WEST SUSSEX COUNTY COUNCIL CONSULTATION

TO:	Arun District Council FAO: David Easton
FROM:	Ian Gledhill County Highways
DATE:	14 th March 2019
SUBJECT:	BE/22/18/DOC Approval of matters reserved by condition imposed under BE/18/17/PL relating to conditions 4- archaeological works, 5-surface water drainage, 9- landscape scheme, 10-protection of existing trees/bushes/shrubs, 14-foul drainage, 15-ecological enhancement scheme, 17-landscape management plan, 18-details of laying out timetable for provisions & future maintenance of Public Open spaces, 20- 10% decentralised & renewable or low carbon energy sources, 21-street lighting scheme, 23- vehicle access, 25-car parking spaces, 27- construction of road(s), footways & casual parking areas & 28- Travel Plan statement. Land West of, New Barn Lane, Bersted
DATE OF SITE VISIT:	N/a
RECOMMENDATION:	☒ Advice ☐ Objection ☐ Modification ☐ No Objection ☐ More Information ☐ Refusal
S106 CONTRIBUTION TOTAL:	£N/a See below for breakdown.

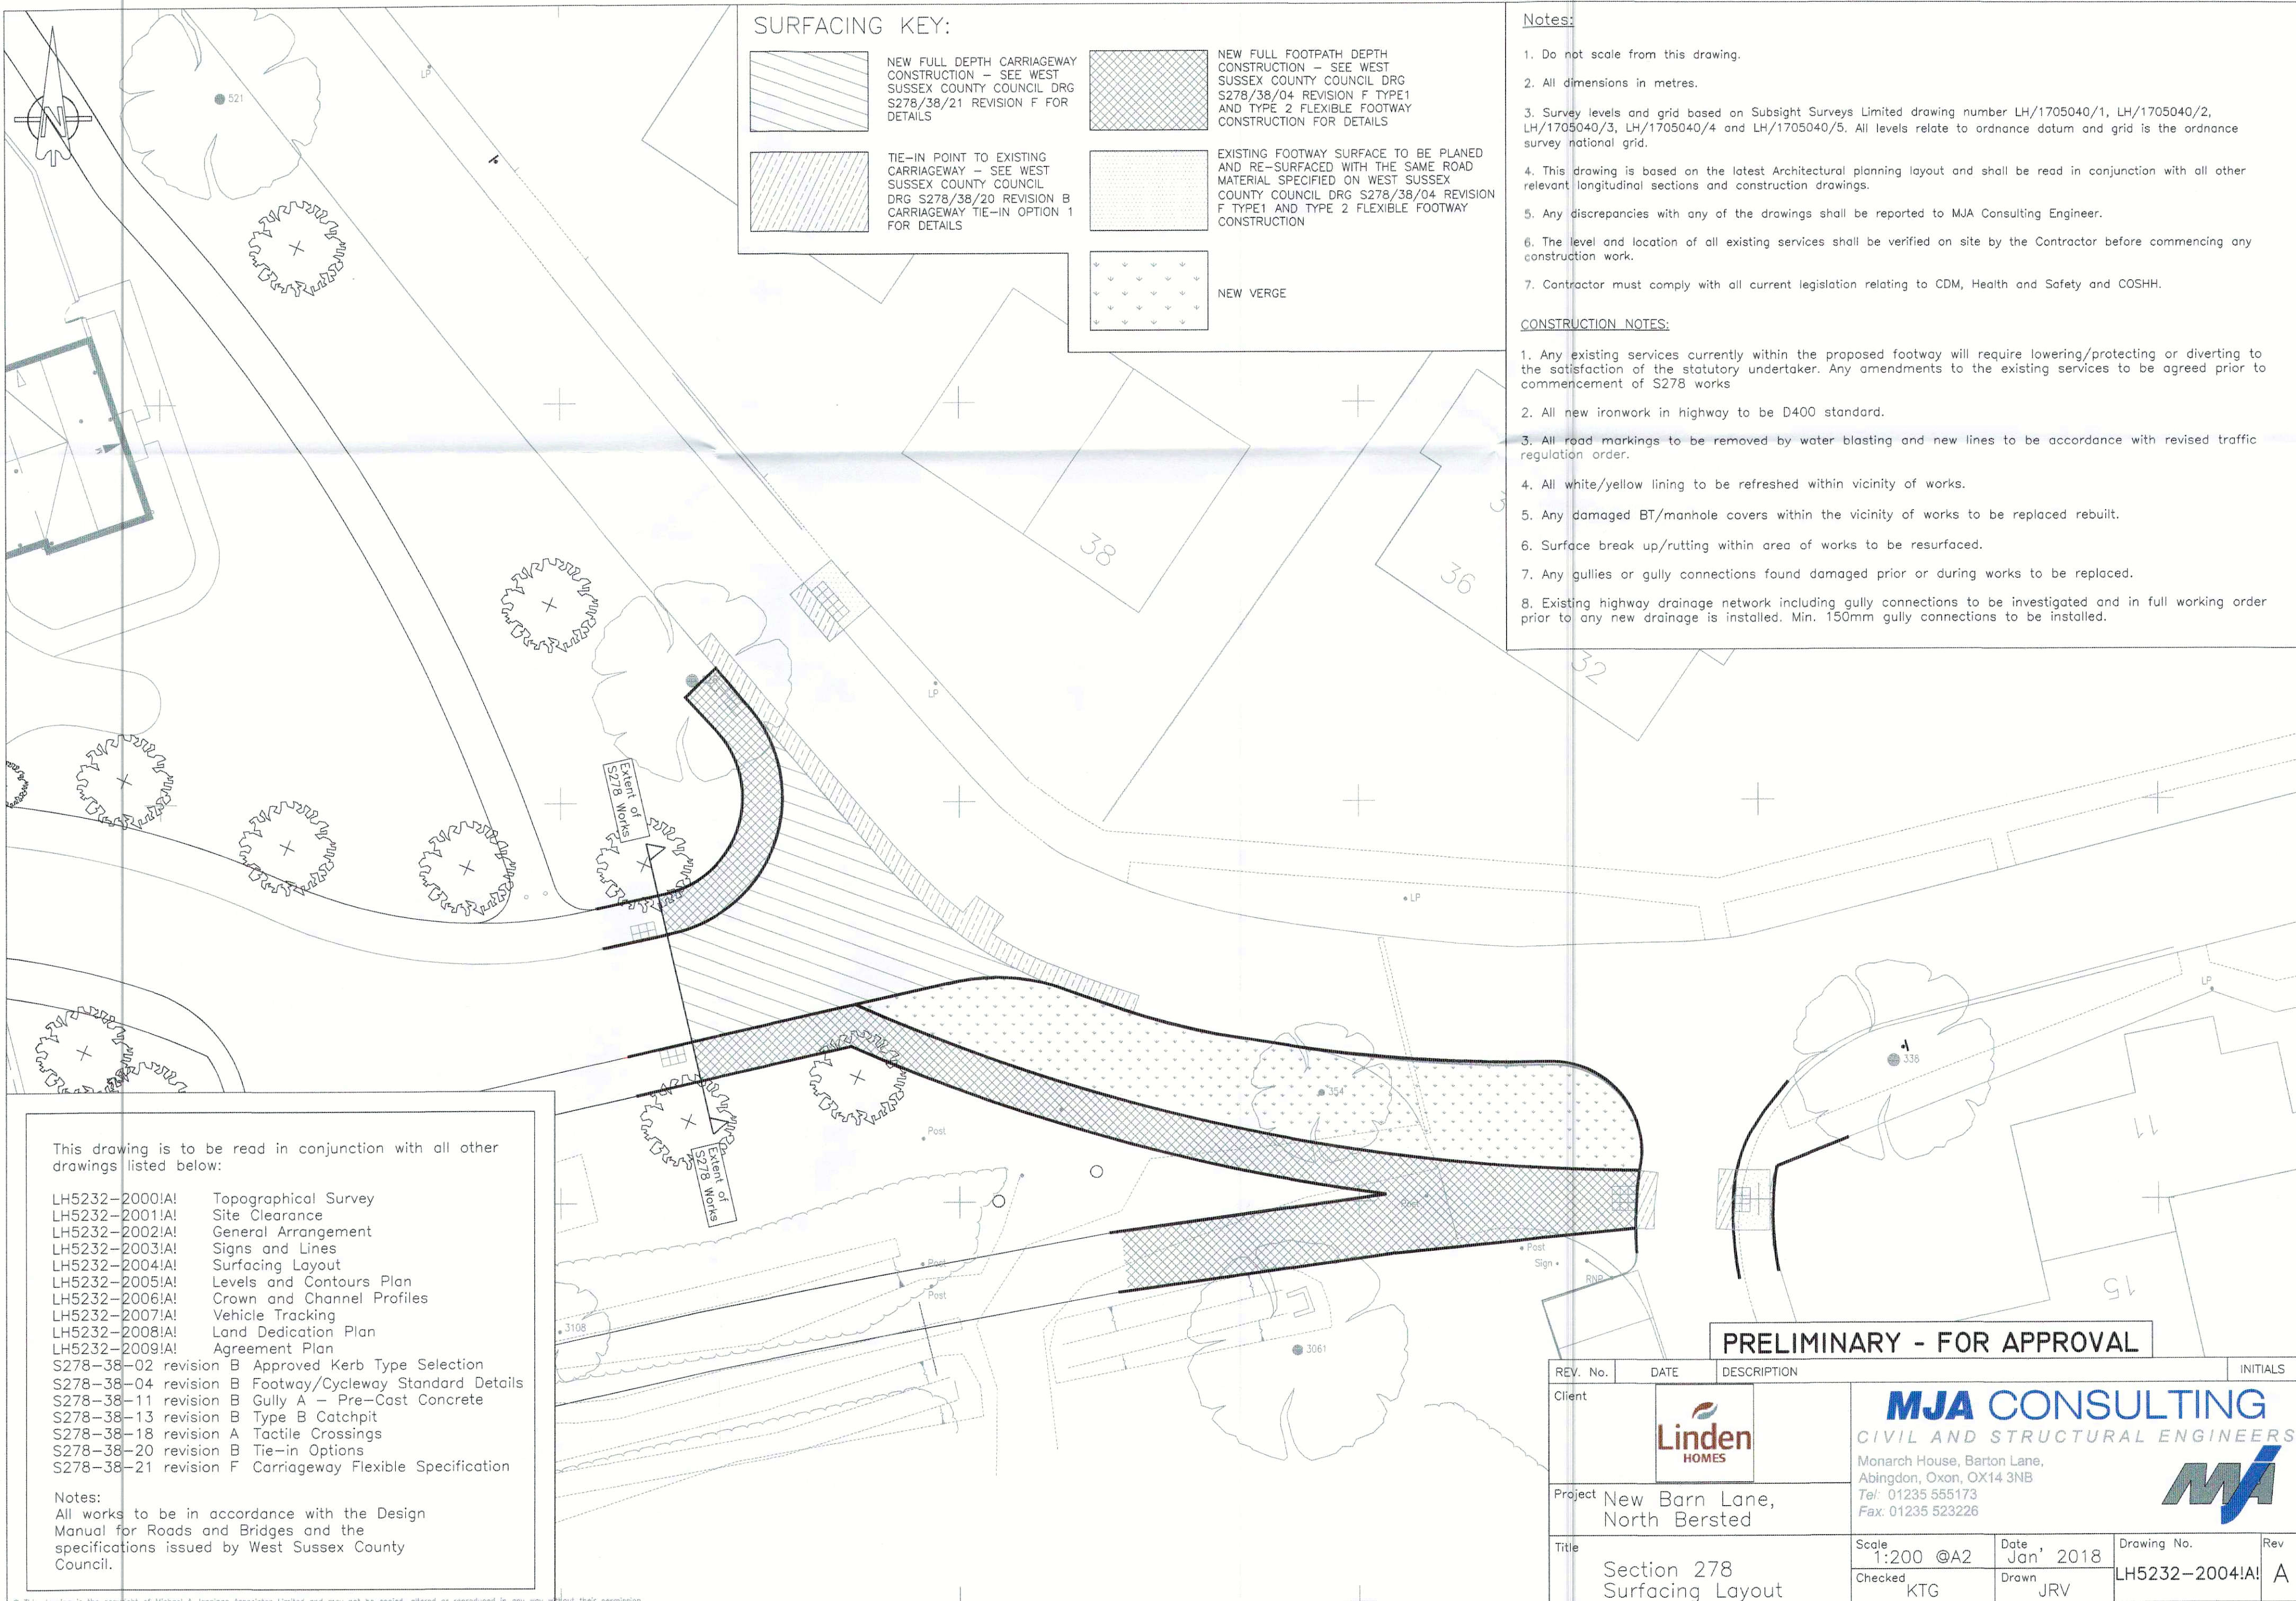
27 (Construction of roads, footways, and casual parking areas) – This condition covers the construction details of the on-site roads. Confirmation would be required from the

applicant as to whether it is the intention for the on-site roads to be offered for adoption as public highway. If the roads are to be adopted, the LHAs mechanism to review the acceptability would be the technical approval associated with the highway adoption agreement. As a result, the LHA could not recommend the discharge of this condition until approval is granted. If the roads are to remain privately maintained, the LPA should satisfy themselves that the roads, footways, and casual parking areas are suitably constructed to safeguard the amenity of future residents.
